DECISION DELEGATED TO HEAD OF PLANNING

Application No: H09-0244-25 **Applicant:** N Marshall
Proposal: Conversion of existing basement to create 1 flat
Location: Westholme 32 West End Holbeach
Terminal Date: 7th May 2025

PROPOSED FLOOR PLANS
 scale 1:100

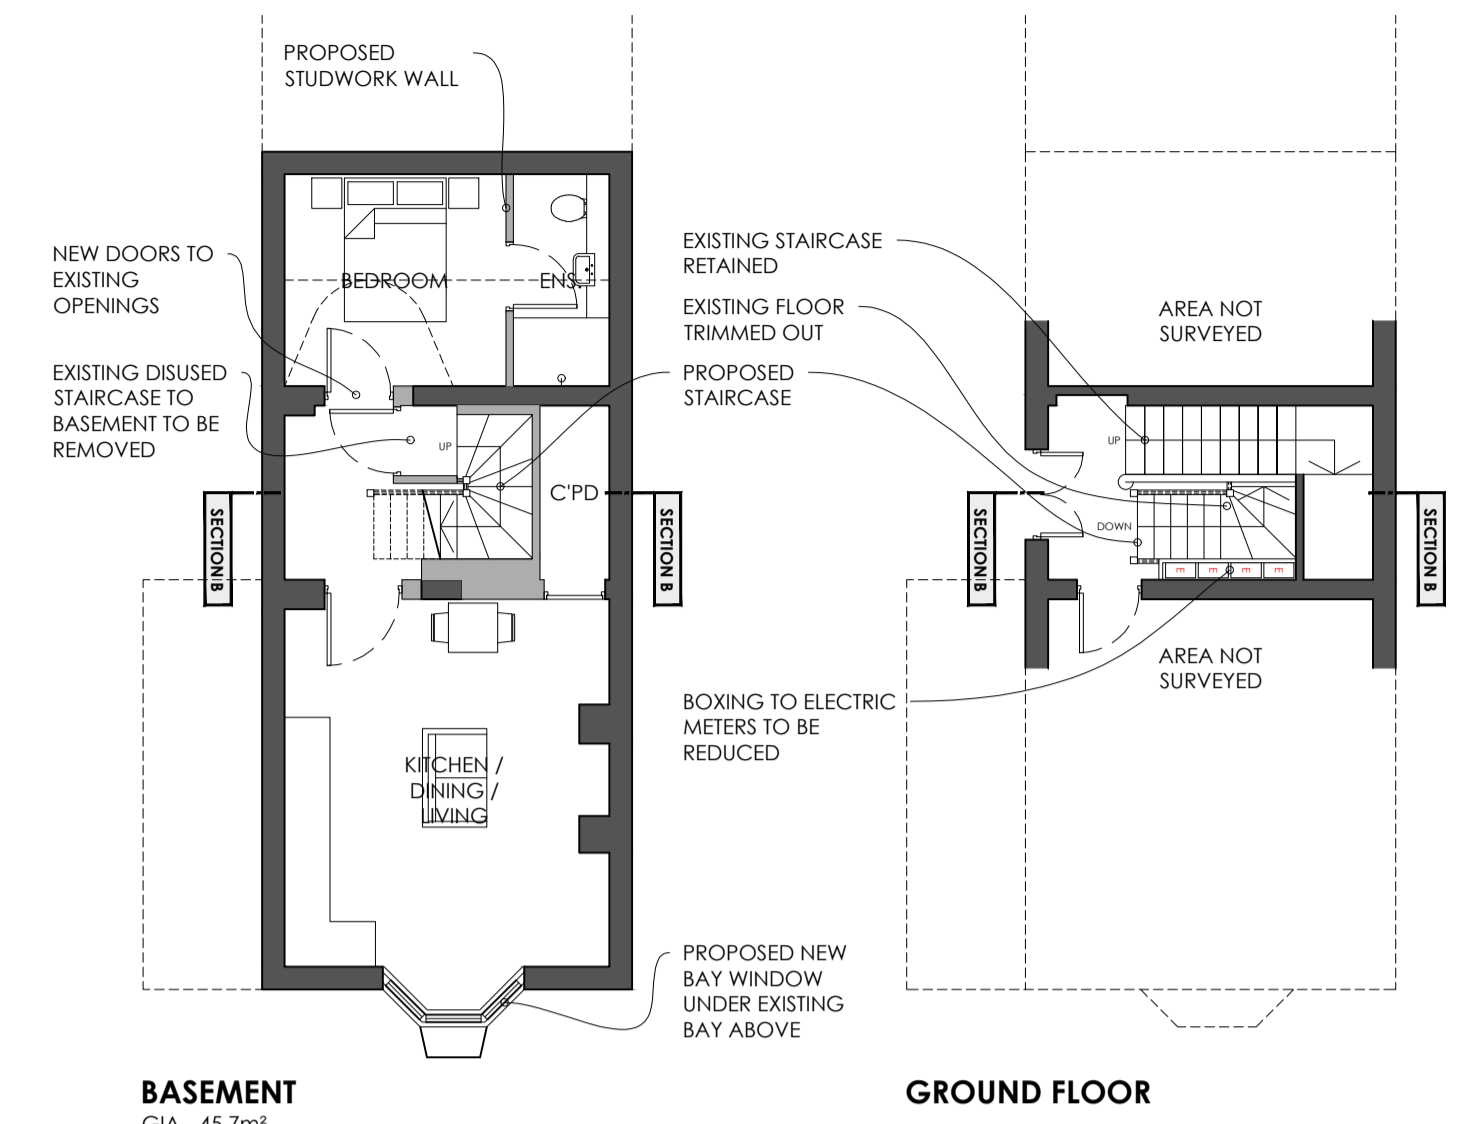
Only one window is proposed for the flat. This window is located at the front of the building and the outlook from this window is mostly blocked due to its position at the basement level. No other windows would be available and as such, most of the living space would not have sufficient natural light or natural ventilation.

Furthermore, the proposed bedroom would have no windows. It is therefore unlikely that there would be sufficient natural light within the flat, and there also would not be a decent outlook for future occupants. This would result in a poor standard of living. Due to the site's location within a

basement, there is no scope to provide additional windows.

The proposed flat would only be provided with one window at the front of the building. It is considered that the provision of one window would not provide enough natural light and ventilation for future occupants. Furthermore, there would not be a decent outlook from the flat for future occupants as most of the window faces onto a blank elevation which appears to be less than a metre from the building. As such, the proposed development would result in a poor standard of living.

PROPOSED ELEVATION
 scale 1:100

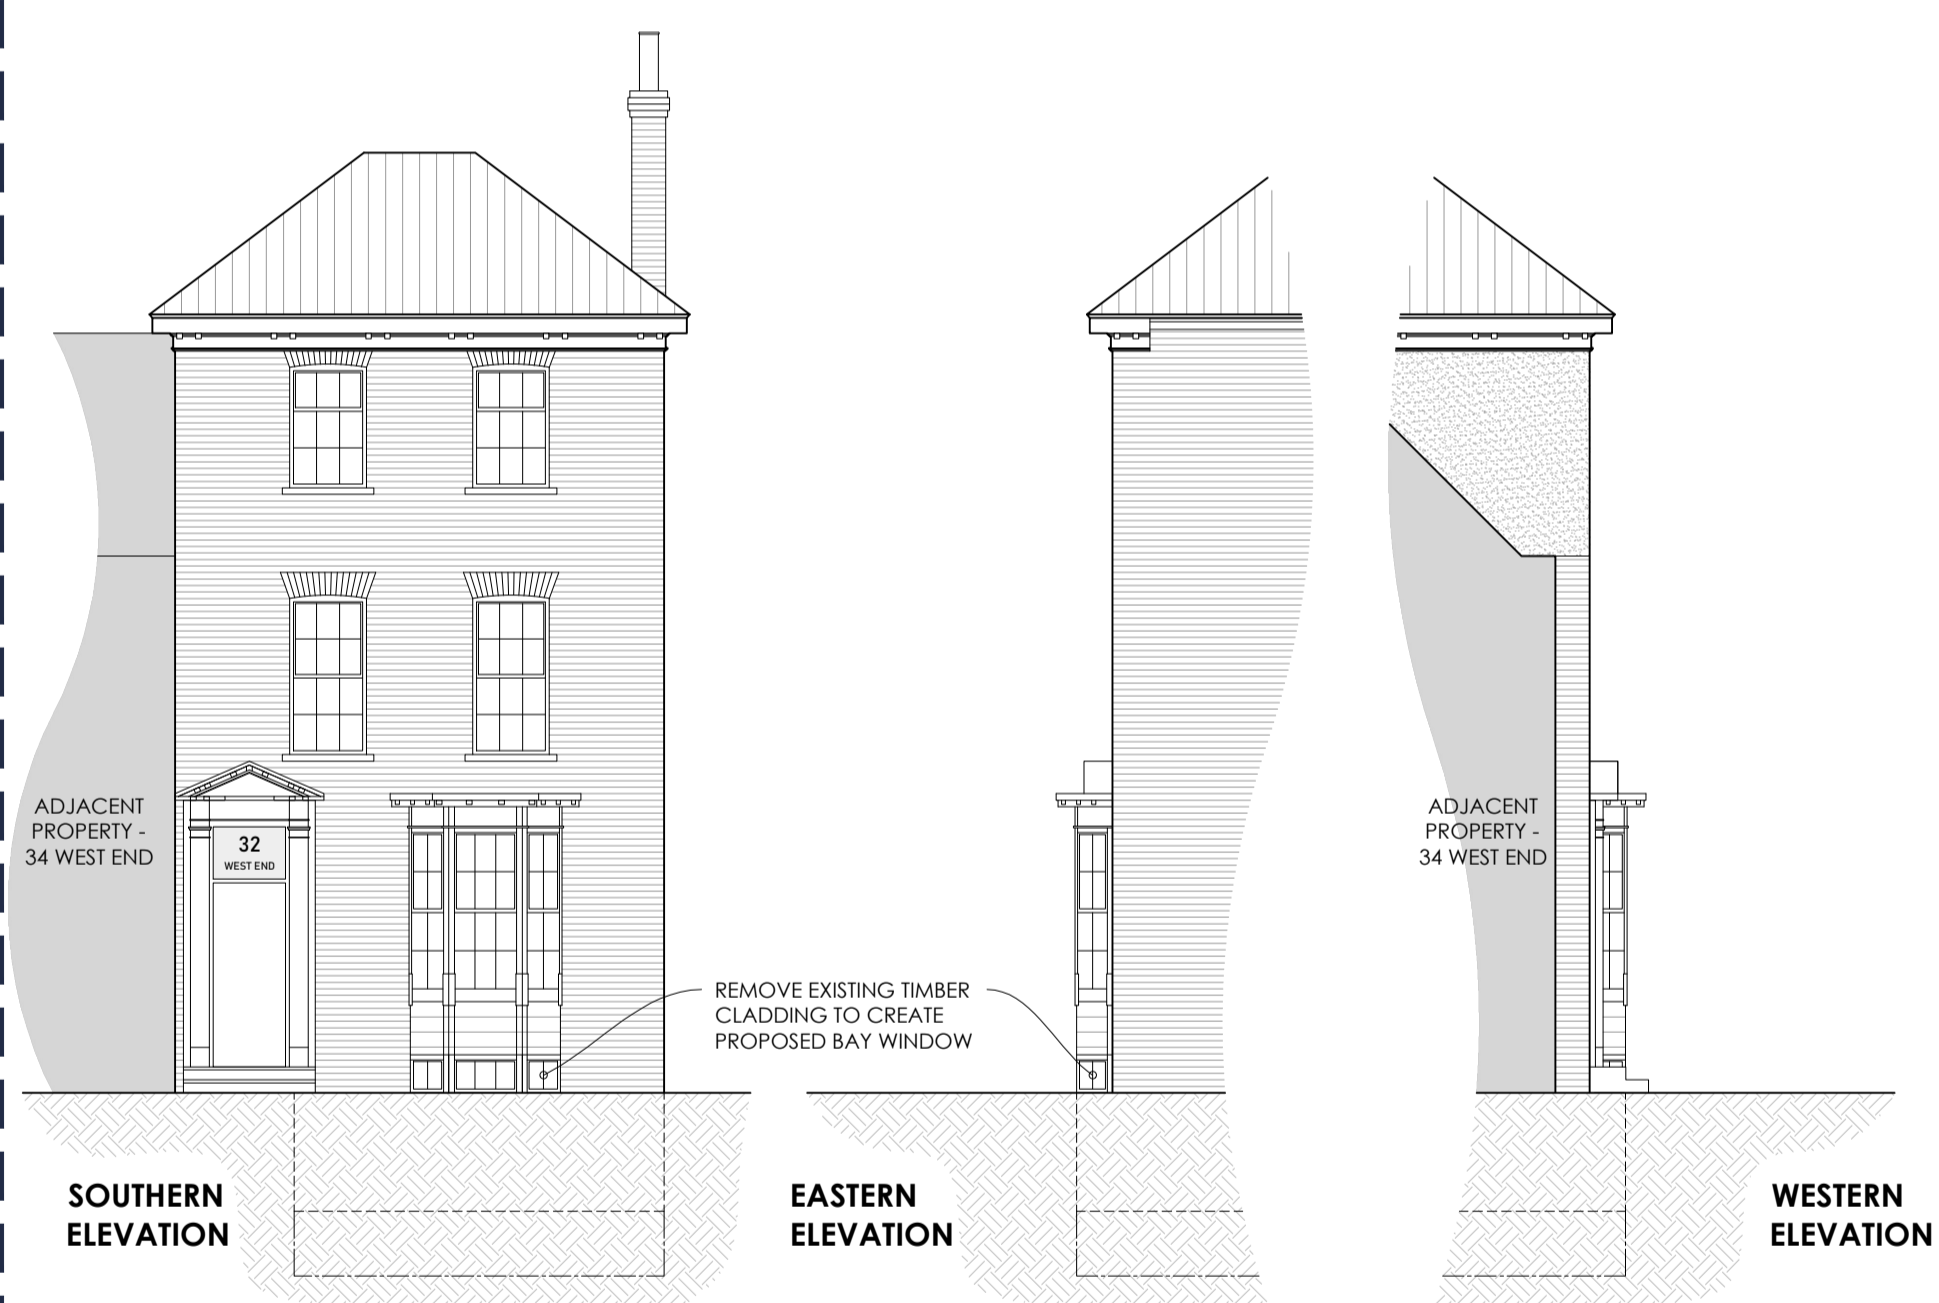
The only external alterations being proposed, comprise the removal of the existing timber cladding to create a bay window, at the front of the building. Other internal alterations are proposed; however, these alterations require listed building consent rather than full planning permission. The internal alterations are pending determination under application H09-0245-25.

The council's conservation officer has set out that they have no objections to the proposed physical alterations to the front of the building, provided that a condition is included to secure further details of the proposed window materials. Subject to the inclusion of such a condition, it is considered that the proposal would not cause an adverse impact on the listed building within the site or the character and appearance of the Conservation Area within which the site is located.
